CITY OF ALBUQUERQUE

February 22, 2017

**Re: Shopping Center
1220 Eubank Blvd. NE
Request 30-Temporary C.O. - Accepted
Engineer's Stamp dated: 3-11-16 (J21D045)
Certification dated: 1-26-17**

GRADING AND DRAINAGE PLAN

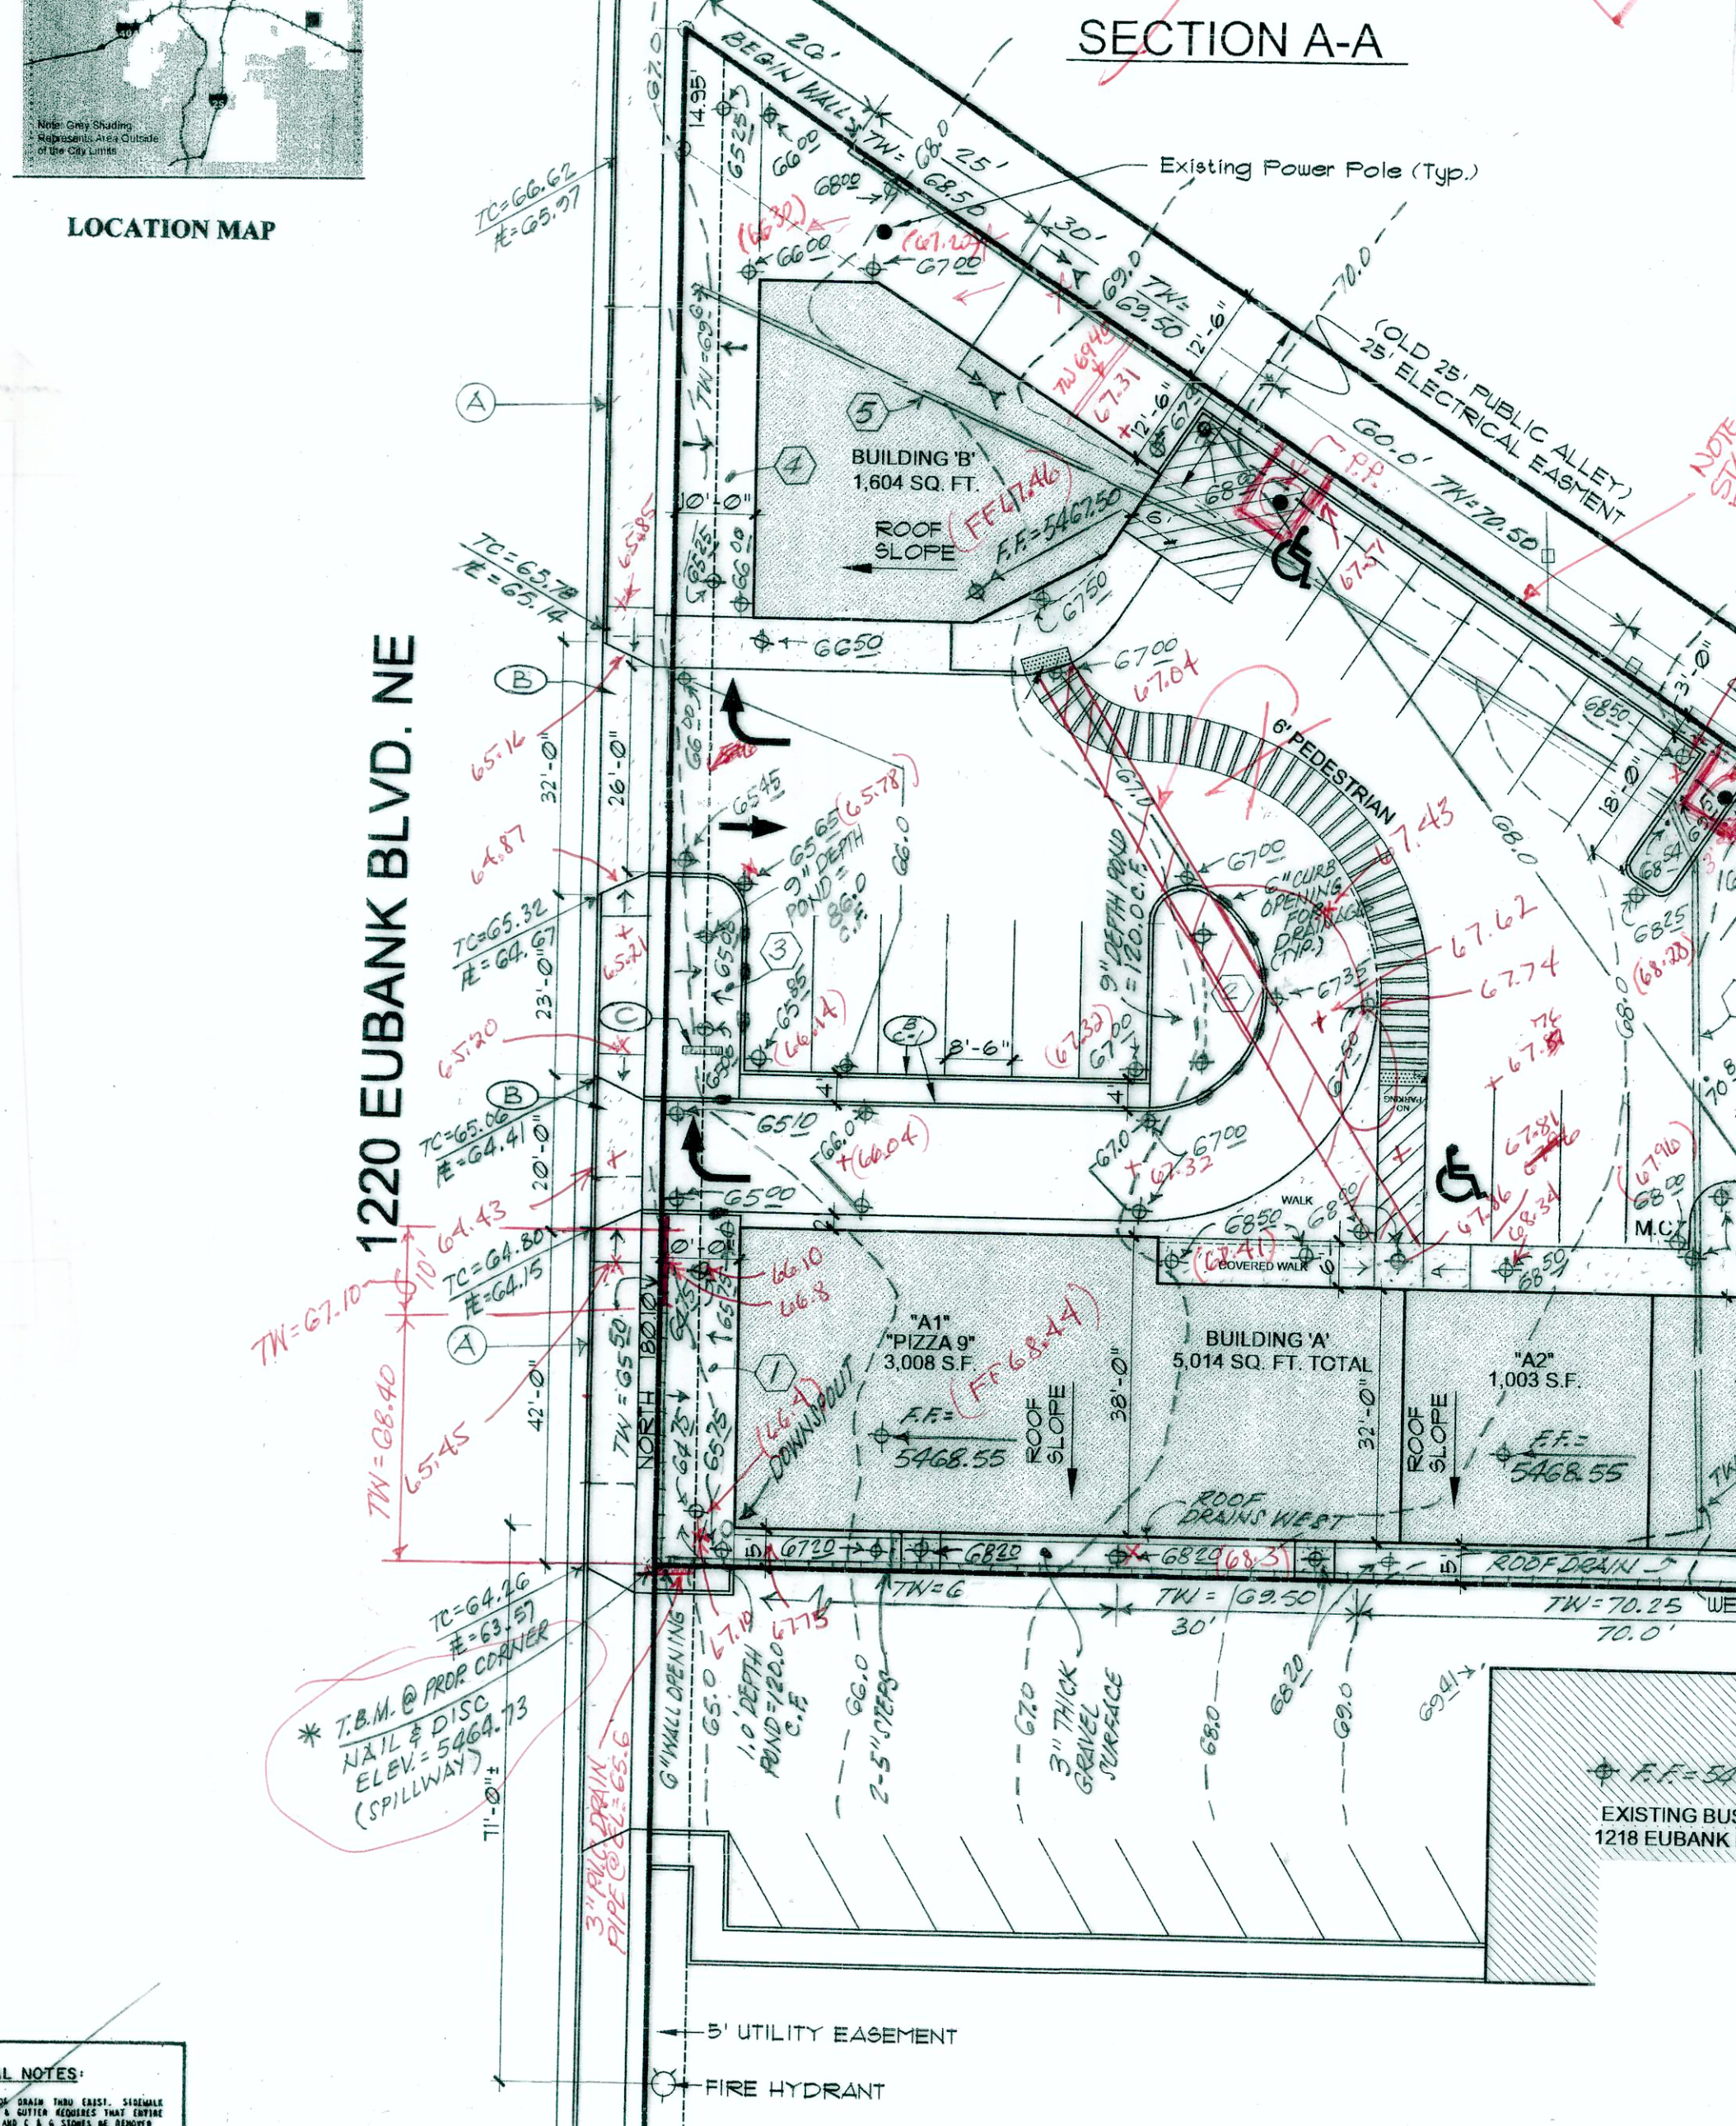
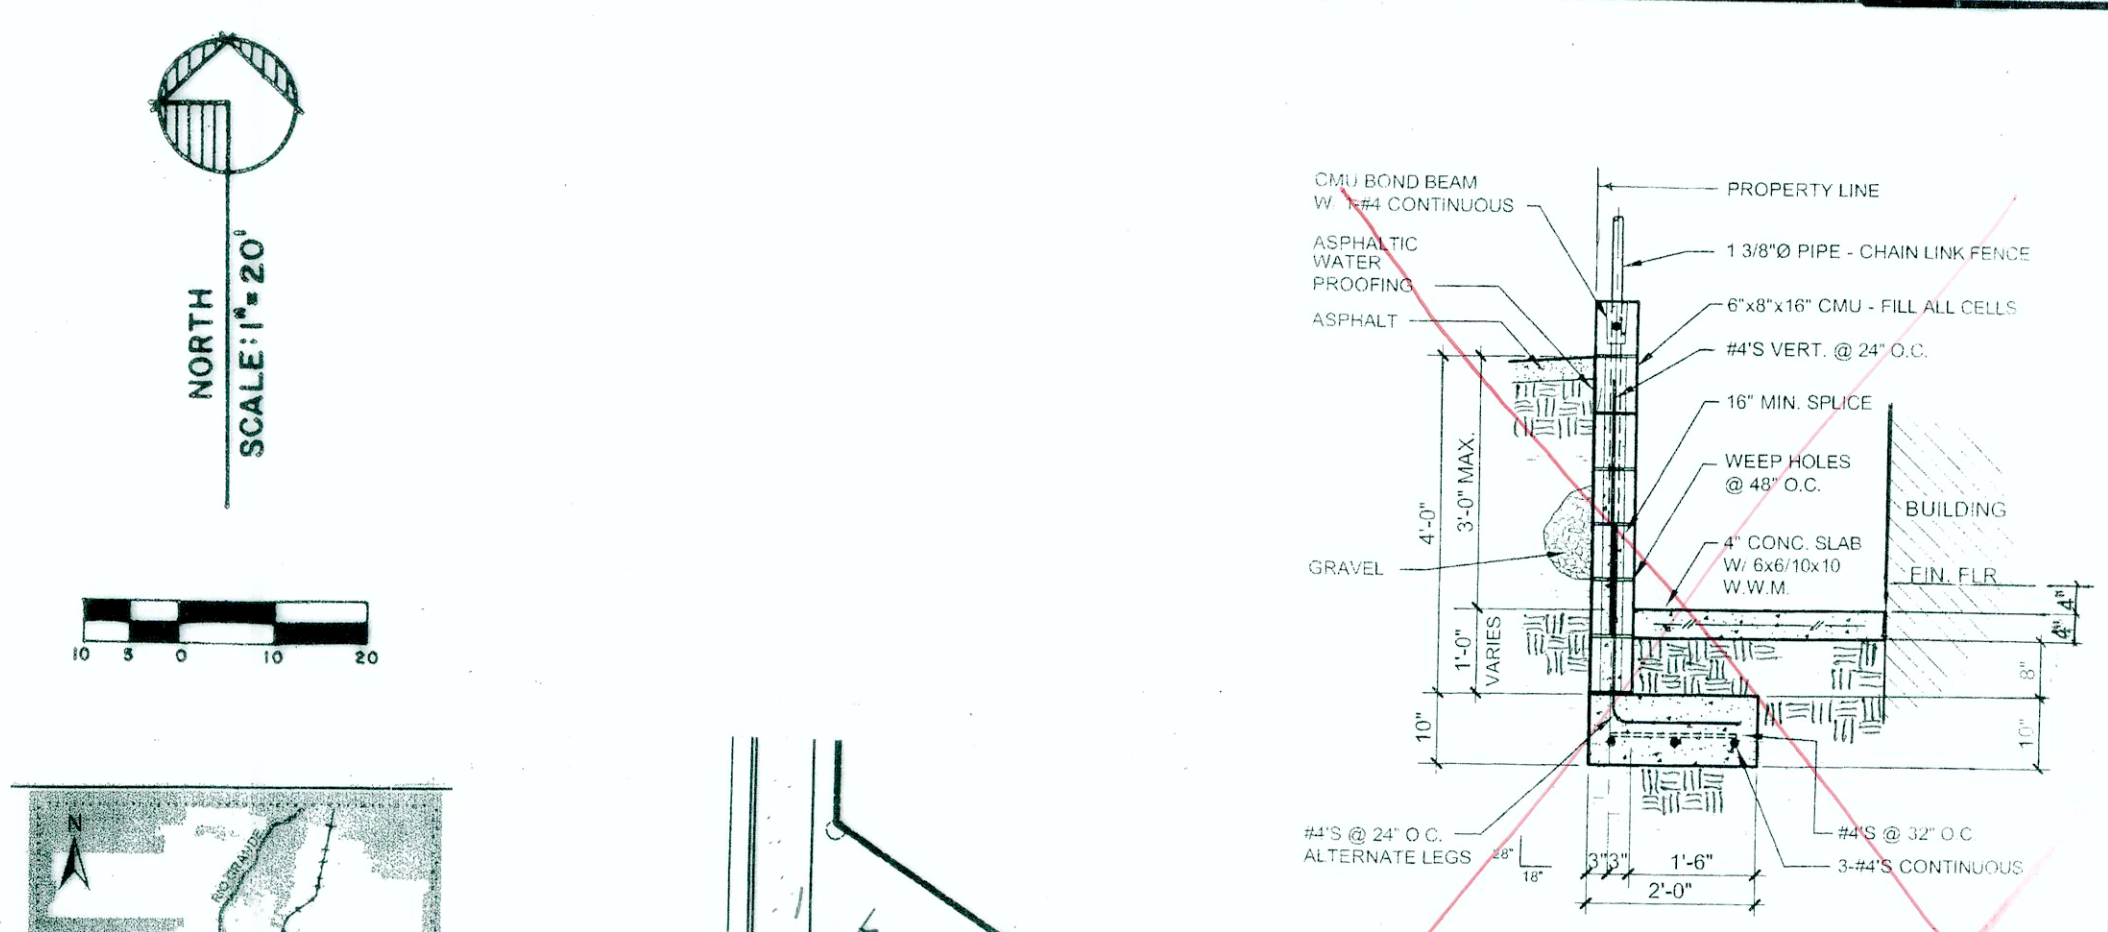
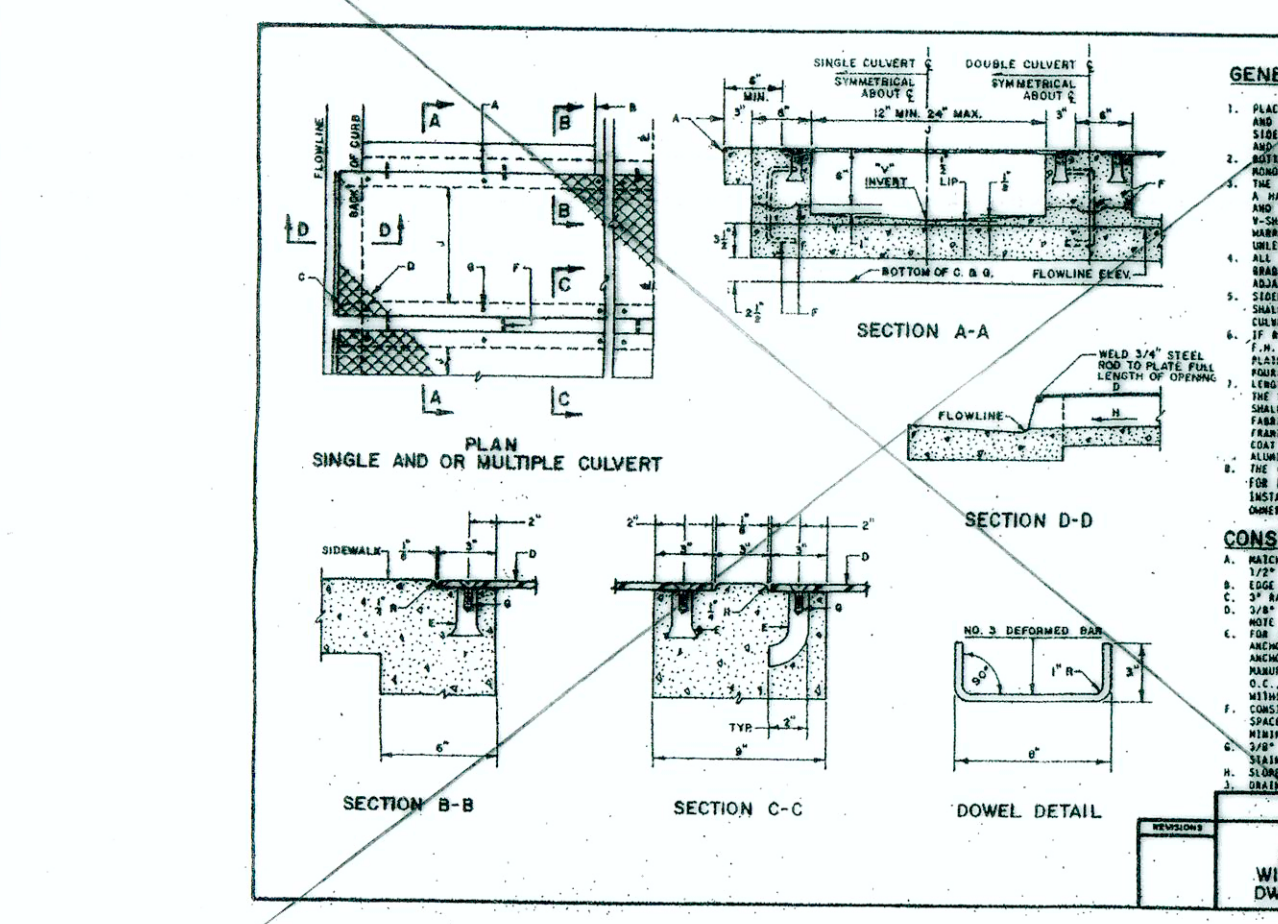
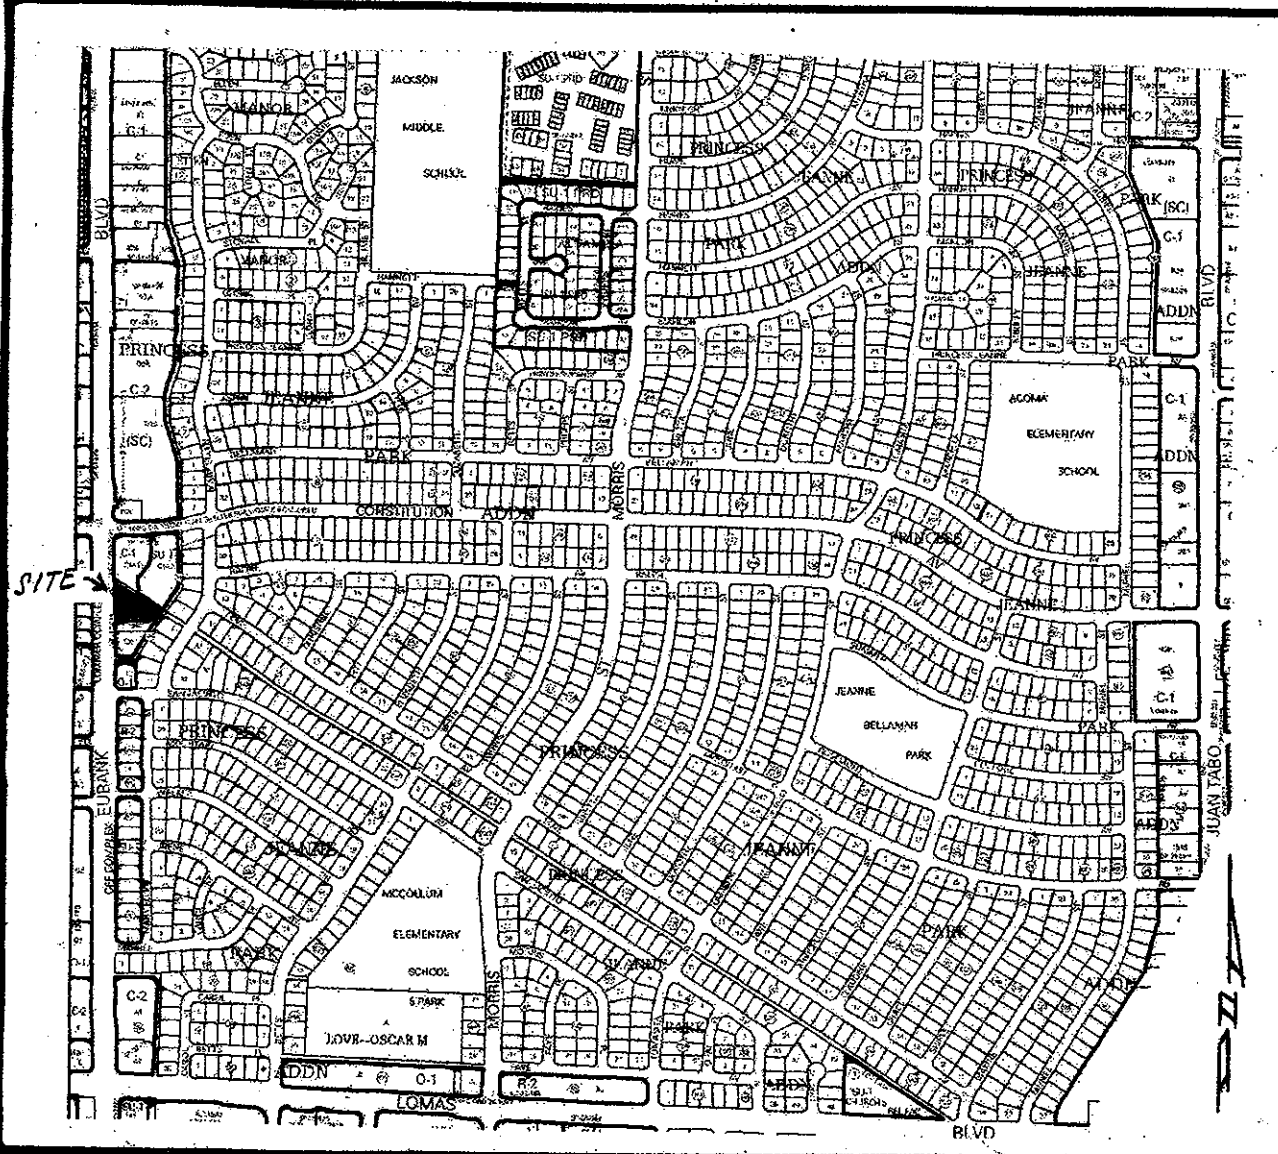
- Alley grades and improvements to be provided. Submit plans thru DRC for approval.
- Pond #1 grades need to be corrected.
- Remove notes referring to pond #2.
- Remove note #1 referring to existing retaining wall.
- Correct drainage on north side against building B.
